January 27, 2000

***RE: NETHERLIN HOMES - 8921 W PAN AM FWAY NE (C18-D51). ENGINEER'S
CERTIFICATION FOR CERTIFICATE OF OCCUPANCY APPROVAL.
ENGINEER'S STAMP DATED JANUARY 10, 2000.***

PROJECT TITLE: NEATHERLIN HOMES ZONE ATLAS/DRNG. FILE #: C18-D51
 DRB #: EPC #: WORK ORDER #: 606781
 LEGAL DESCRIPTION: LOT 9 BLK 10 TRA UNIT B NAA.
 CITY ADDRESS: 8921 WEST PAN AMERICAN FWY NE

NEATHERLIN HOMES
GRADING & DRAINAGE PLAN

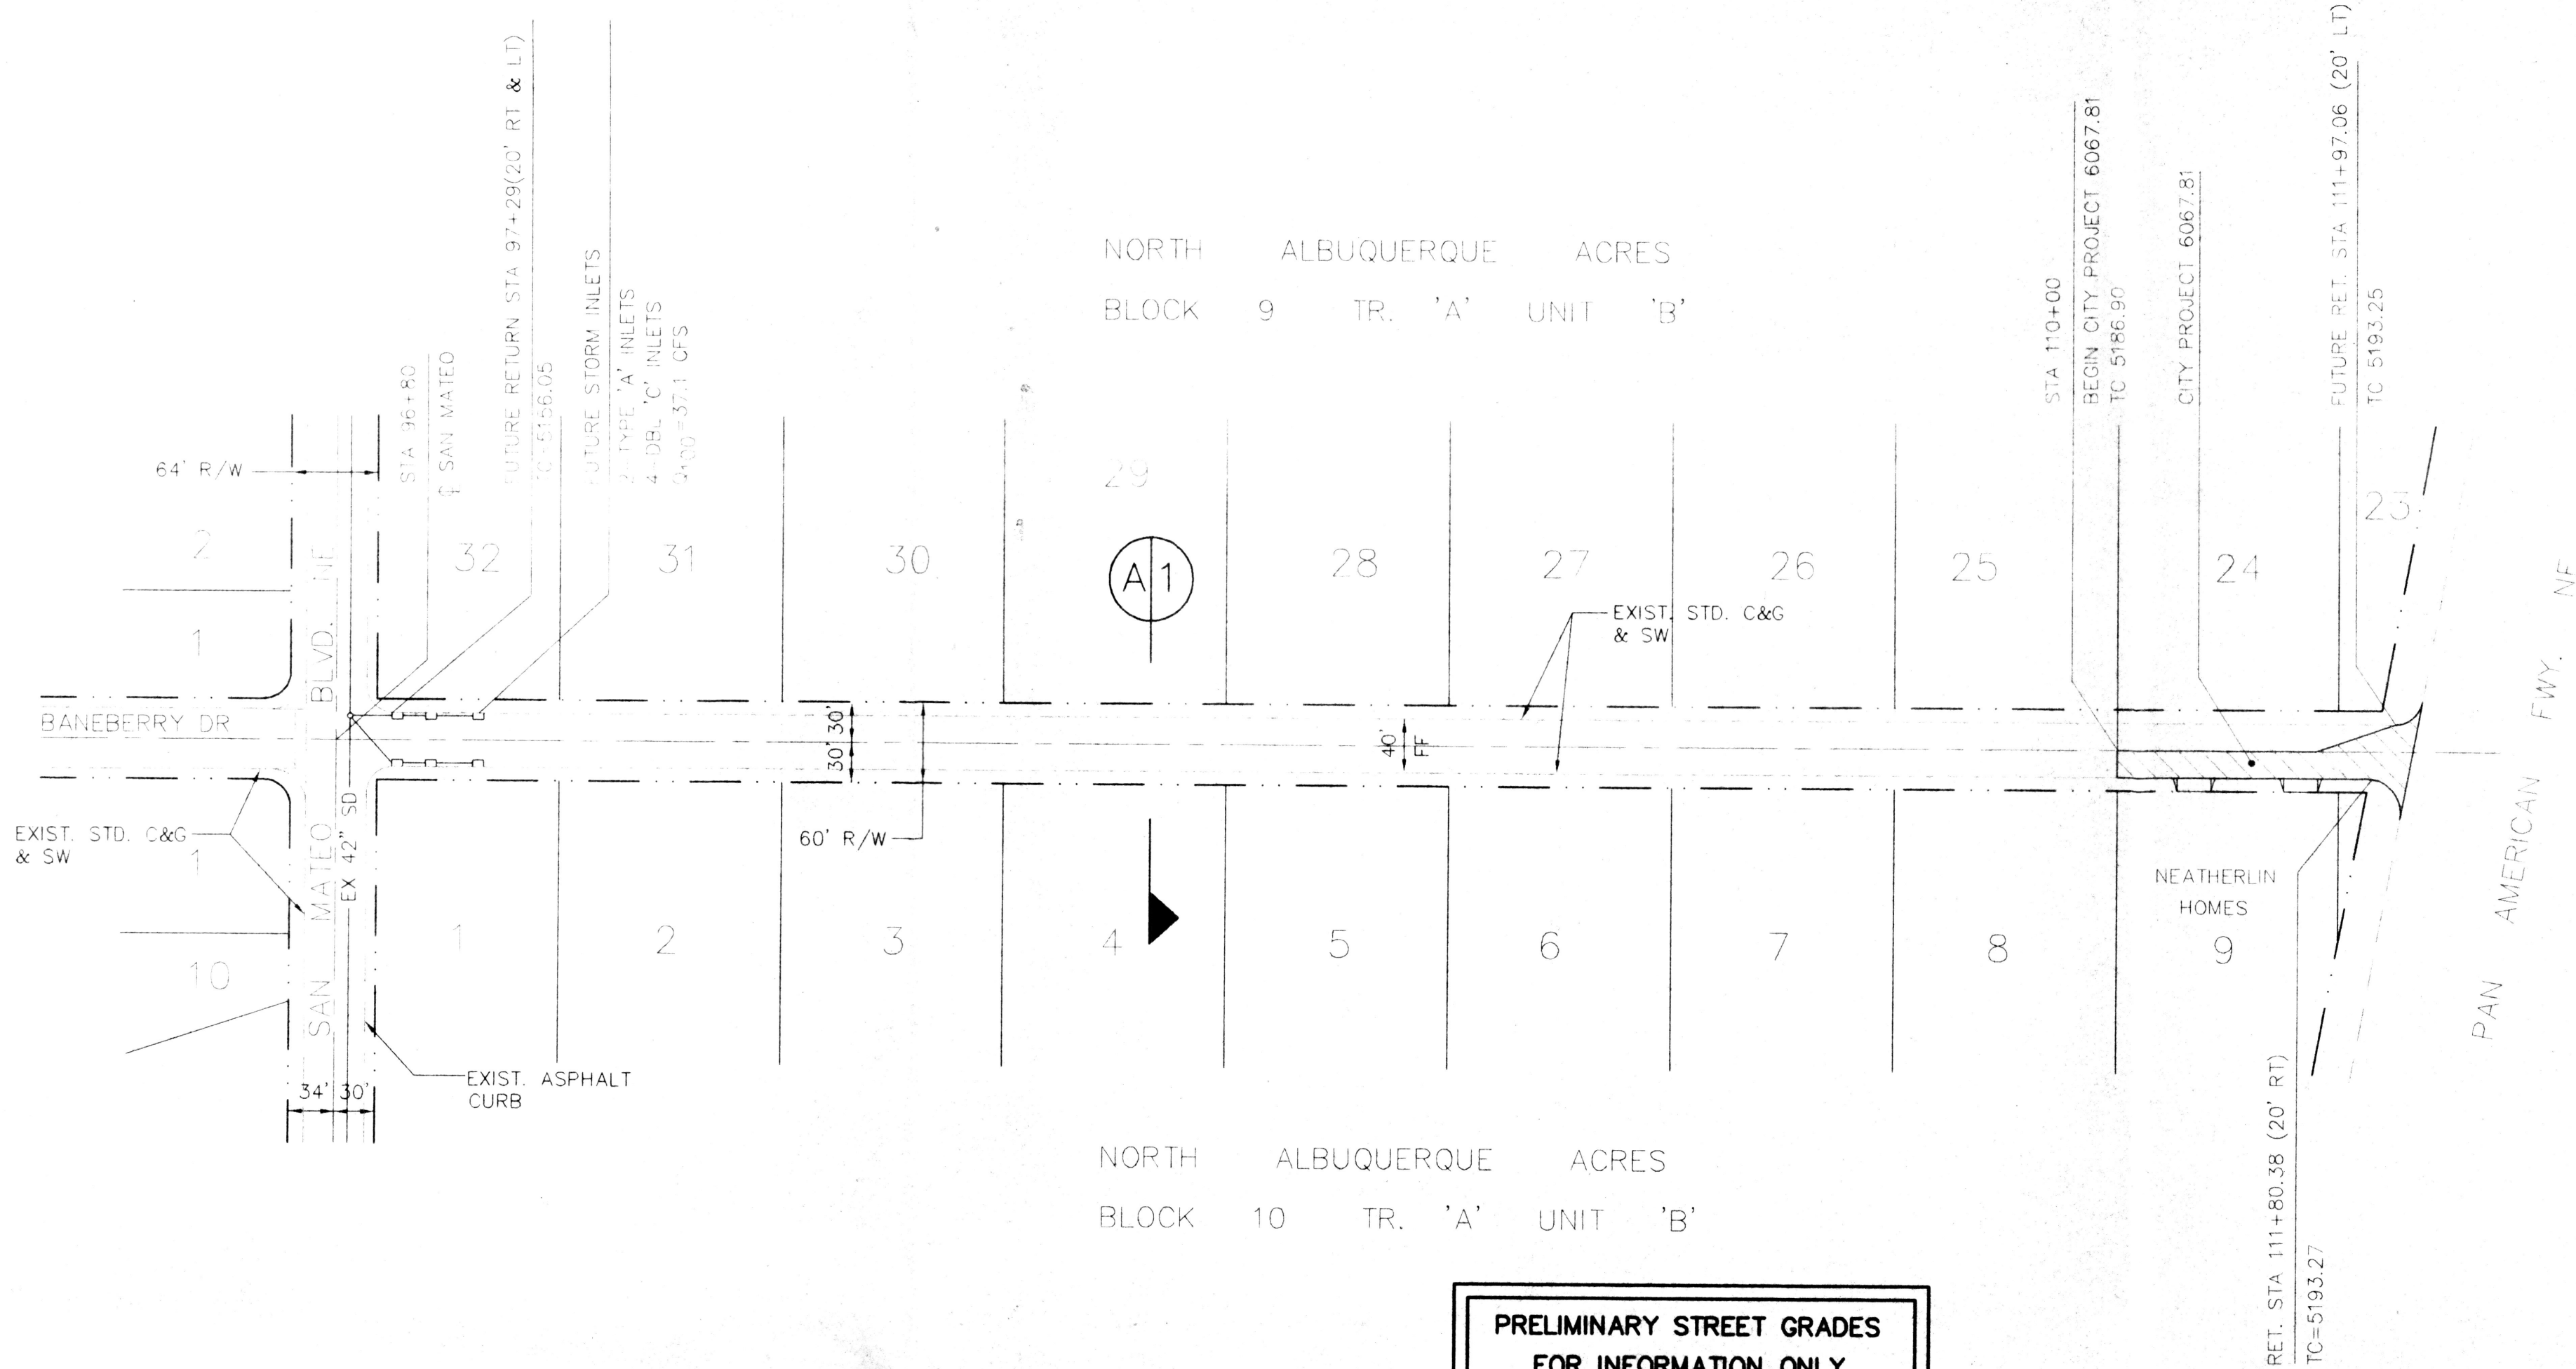
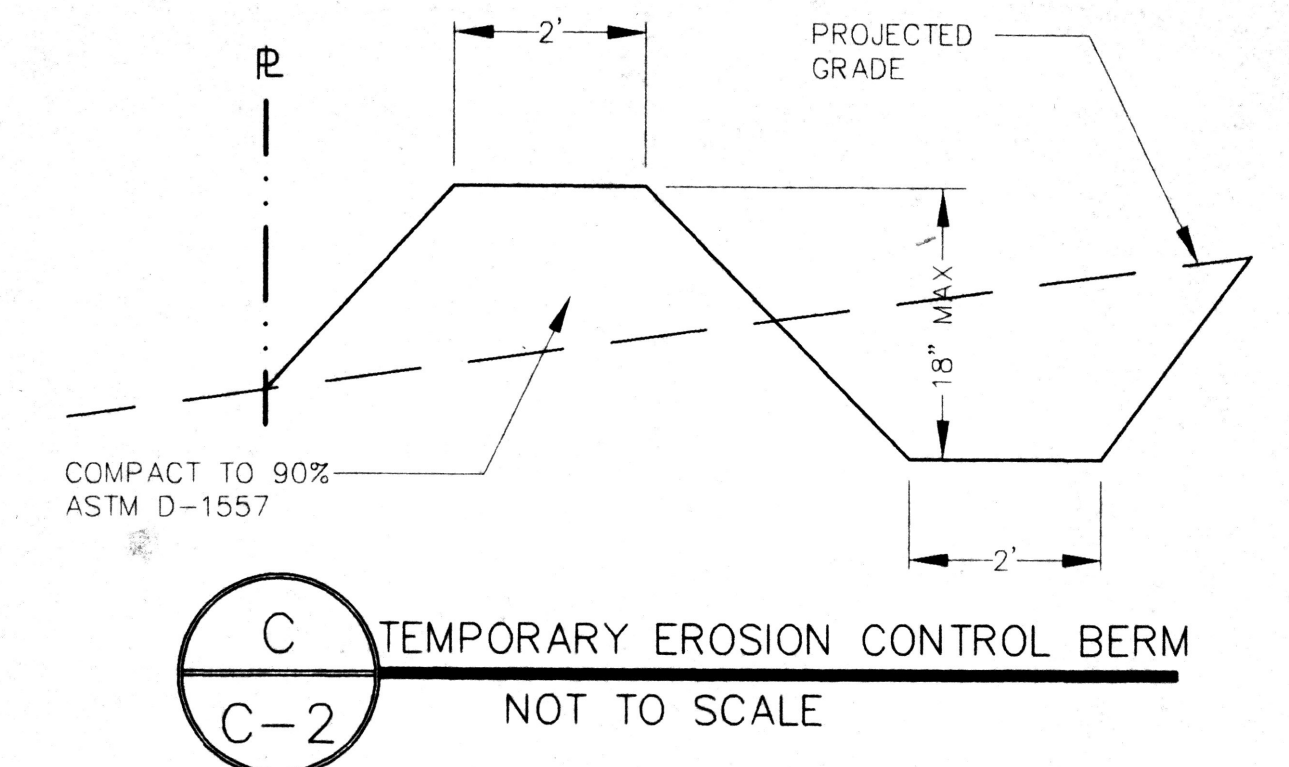
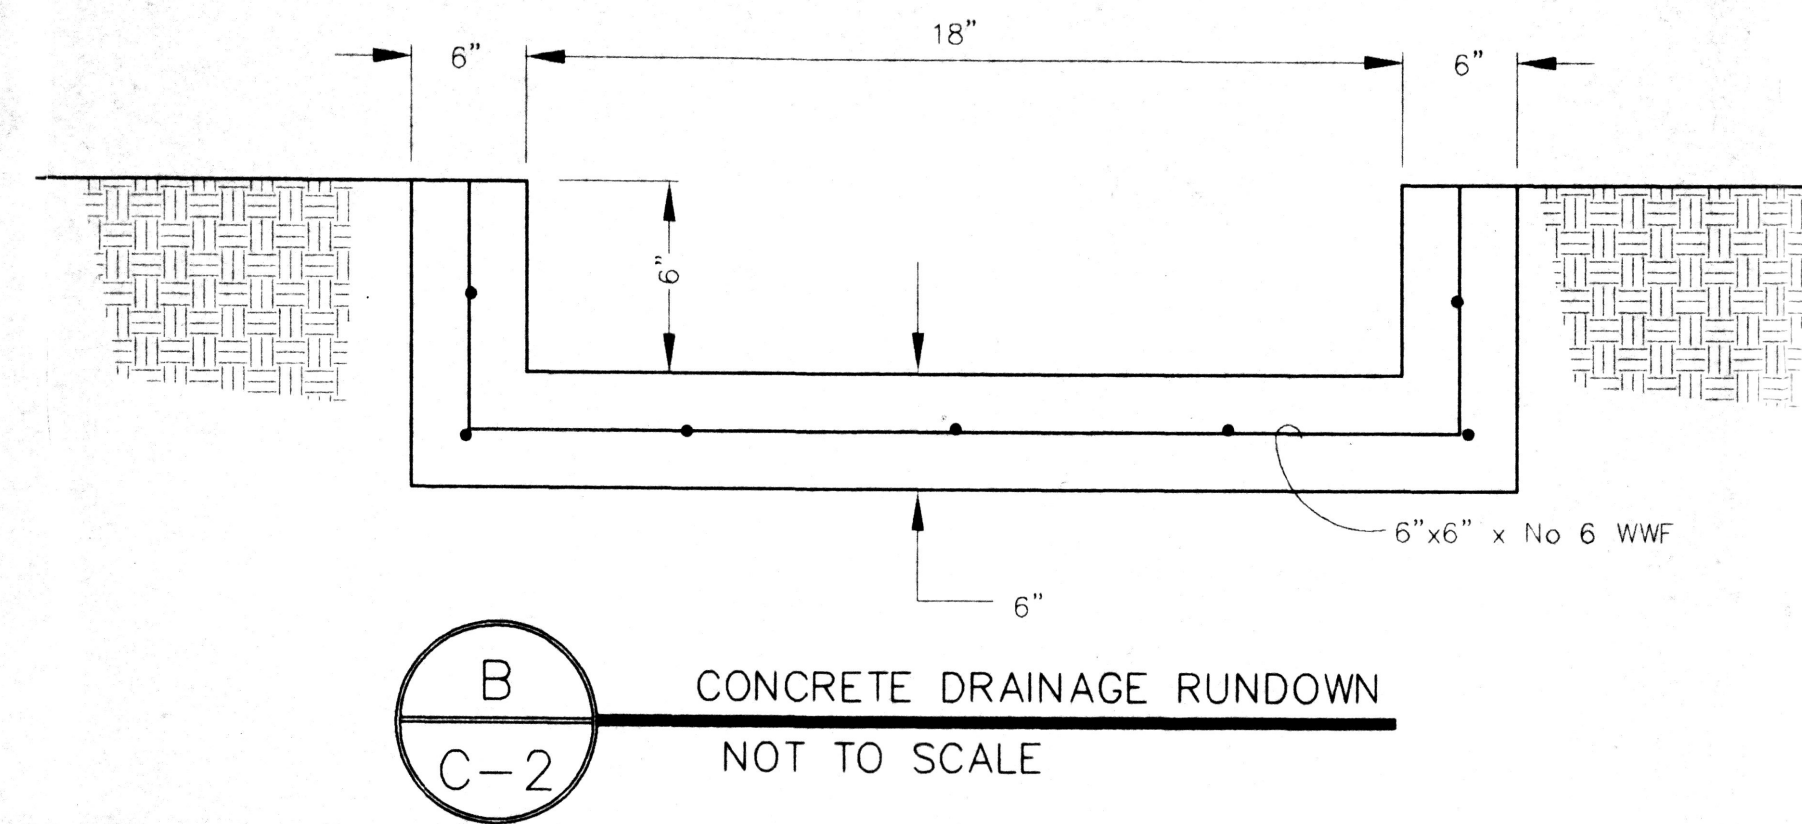
Since the construction of downstream improvements (by others) is in progress, the reduced pond capacity should suffice for the interim.
